WEST SUSSEX COUNTY COUNCIL

Land East of Tye Lane, Walberton.

Road Safety Audit Log cover sheet

This report should be read in conjunction with the Stage 1 Safety Audit ref 183248-08

VIEWPORT 1 - PROPOSED RESIDENTIAL ACCESS AT TYE LANE

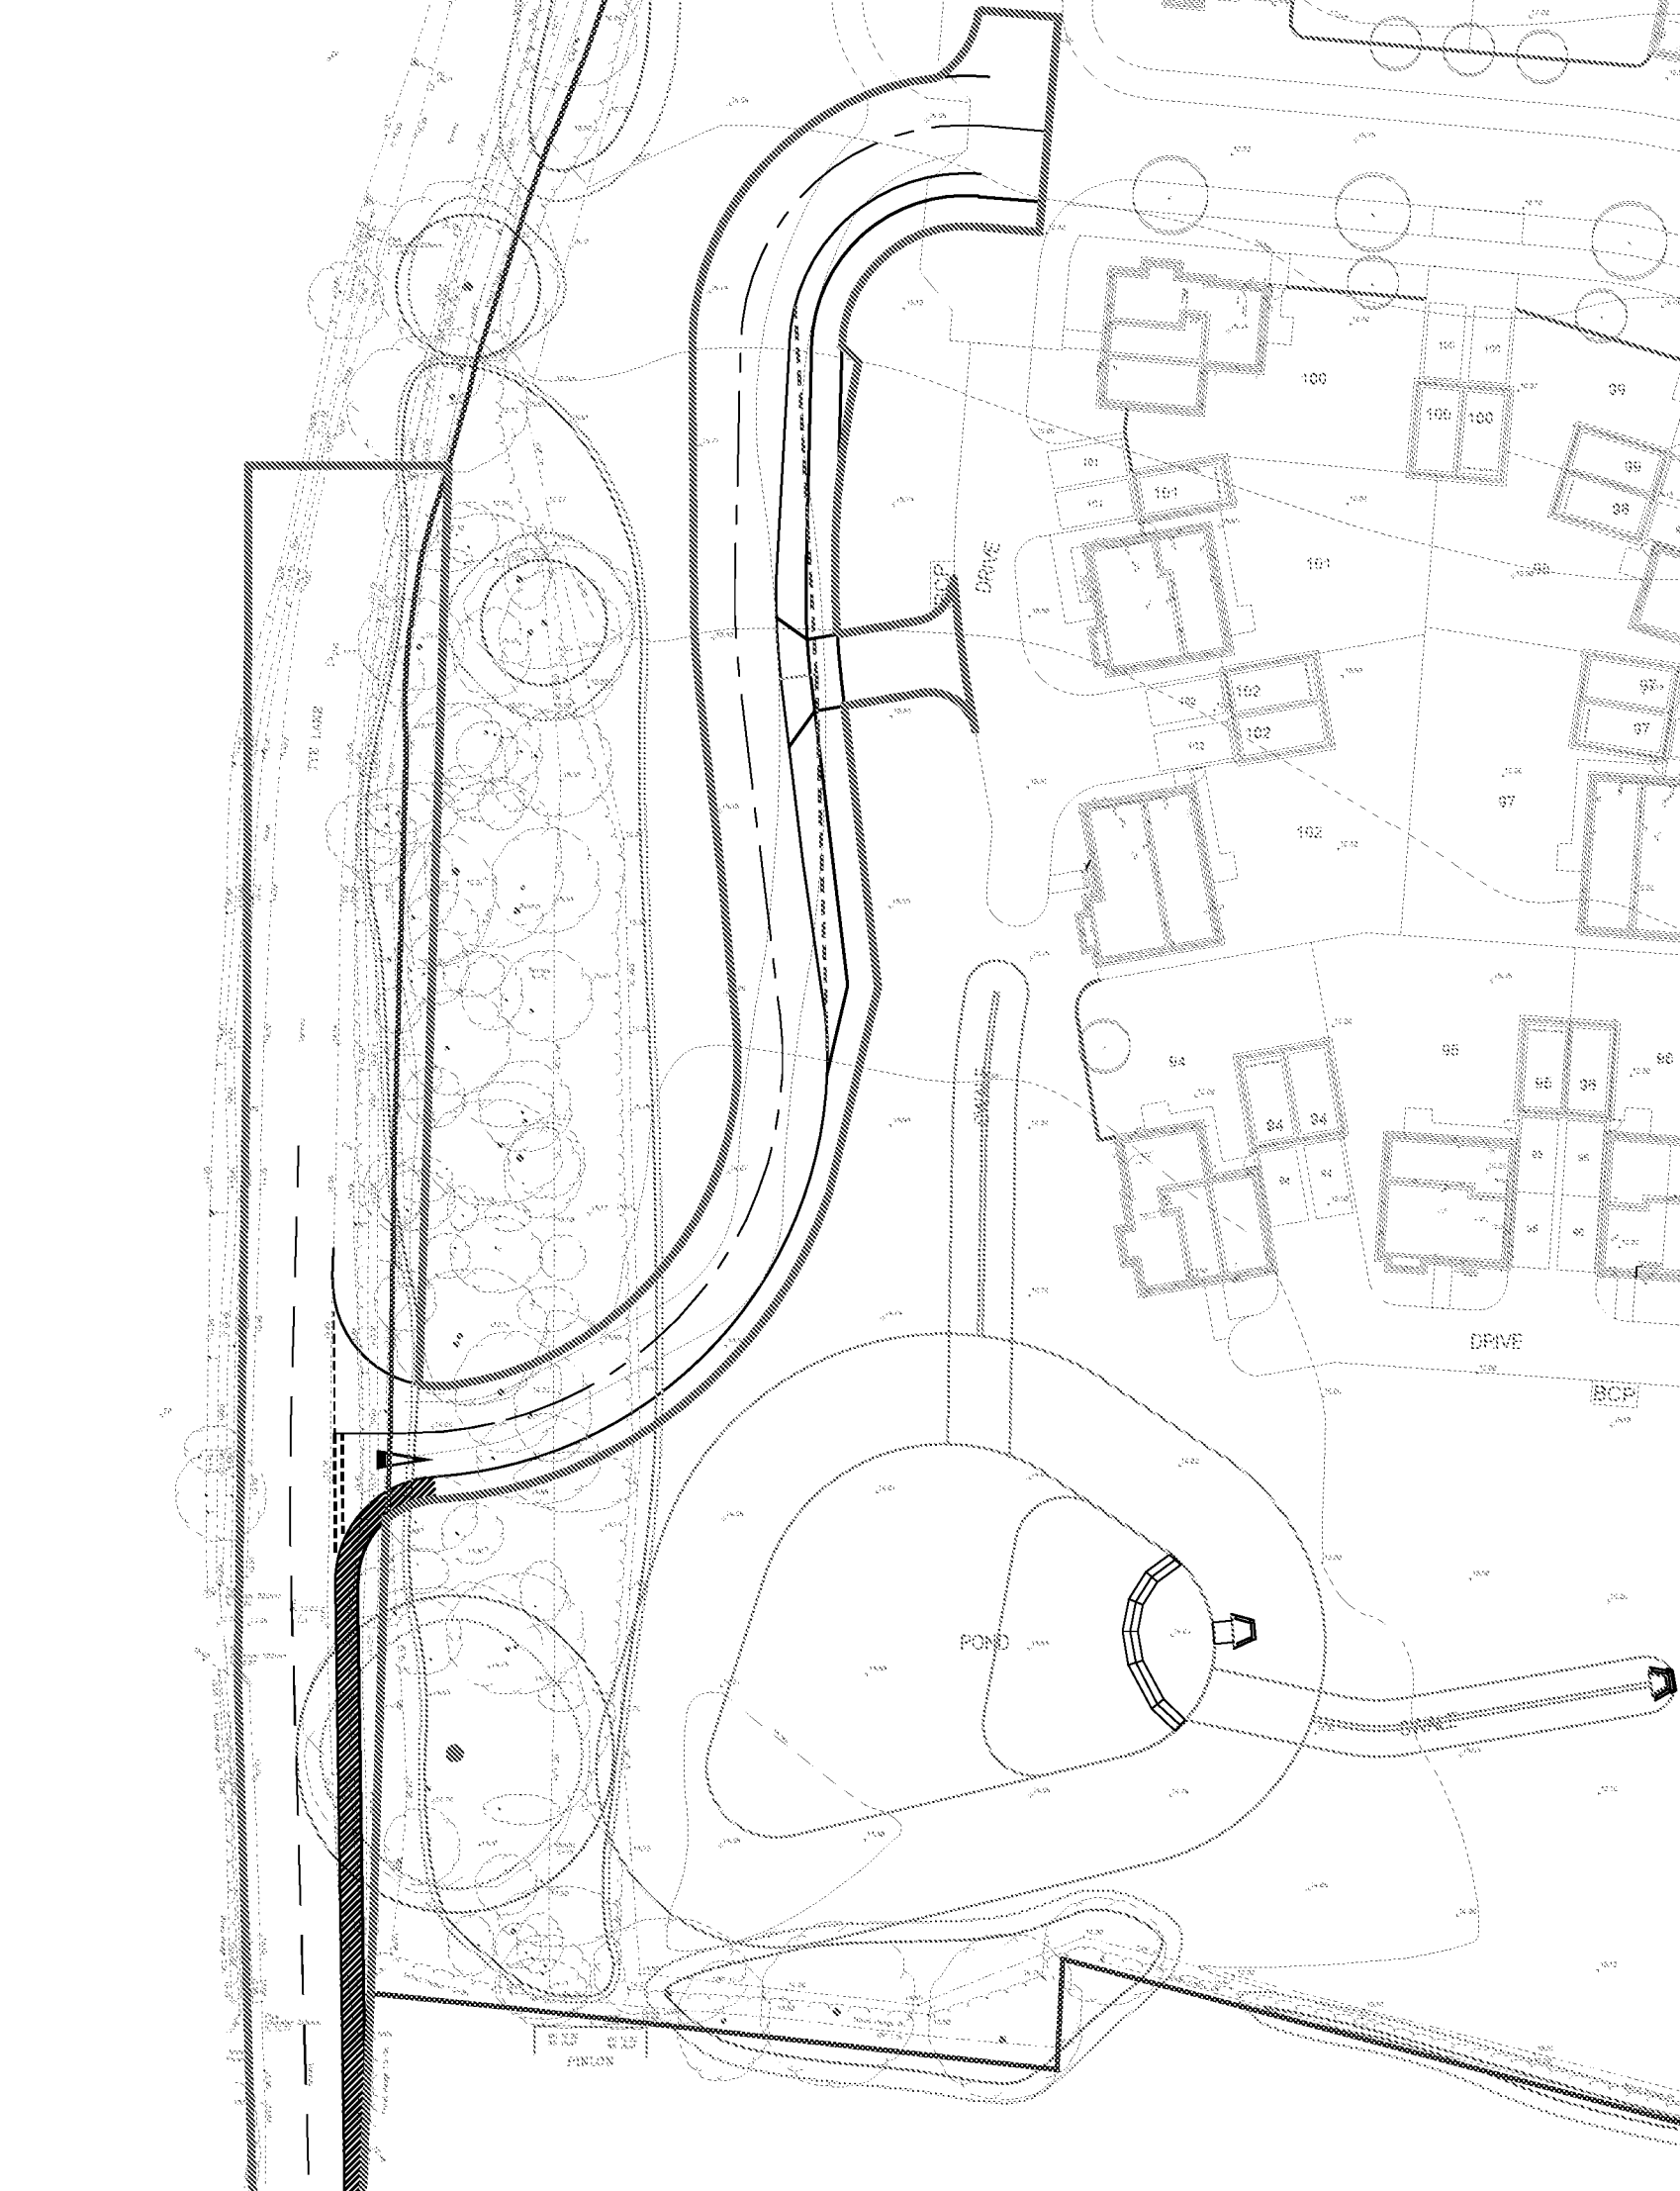
Para No.	Problem (as identified by Safety Auditor)	Recommendations (Made by Safety Auditor)	Designer's Response	Proposals
3.2.2	Insufficient carriageway space could lead to side swipe collisions. No swept path information has been provided for assessment, where the junction mouth is being narrowed due to the proposed footway provision. Insufficient turning space may lead to larger vehicles entering the opposing carriageway. This could lead to possible side swipe collisions or head on collisions; however, in CD123 'Geometric design of at-grade priority and signal controlled junctions' under paragraph 5.2 it is stated that: <i>Allowance shall be made for the swept turning paths of the worst-case design vehicle, which is expected to use the priority junction, unless:</i> <i>1. the design vehicle is expected to form only a very small percentage of the total number of vehicles that will use the junction; and</i> <i>2. any swept path conflicts as a result of the design vehicle encroaching into other lanes will not occur on bends..</i>	It is recommended that the junction should be eased to allow access and egress by large vehicles without incursion into opposing lanes by the more frequent usage vehicles; unless in line with CD123, these movements form only a small percentage of vehicle movements.	Vehicle tracking has been provided and shows a refuse vehicle would over run the centre line of the junction of Tye Lane and The Street, given the low speed environment and low level of existing trips circa 900 per day (2018 count) on Tye Lane which would be making the movement of which only a small % would be heavy vehicles then no further concern is raised.	Item resolved no further action required.
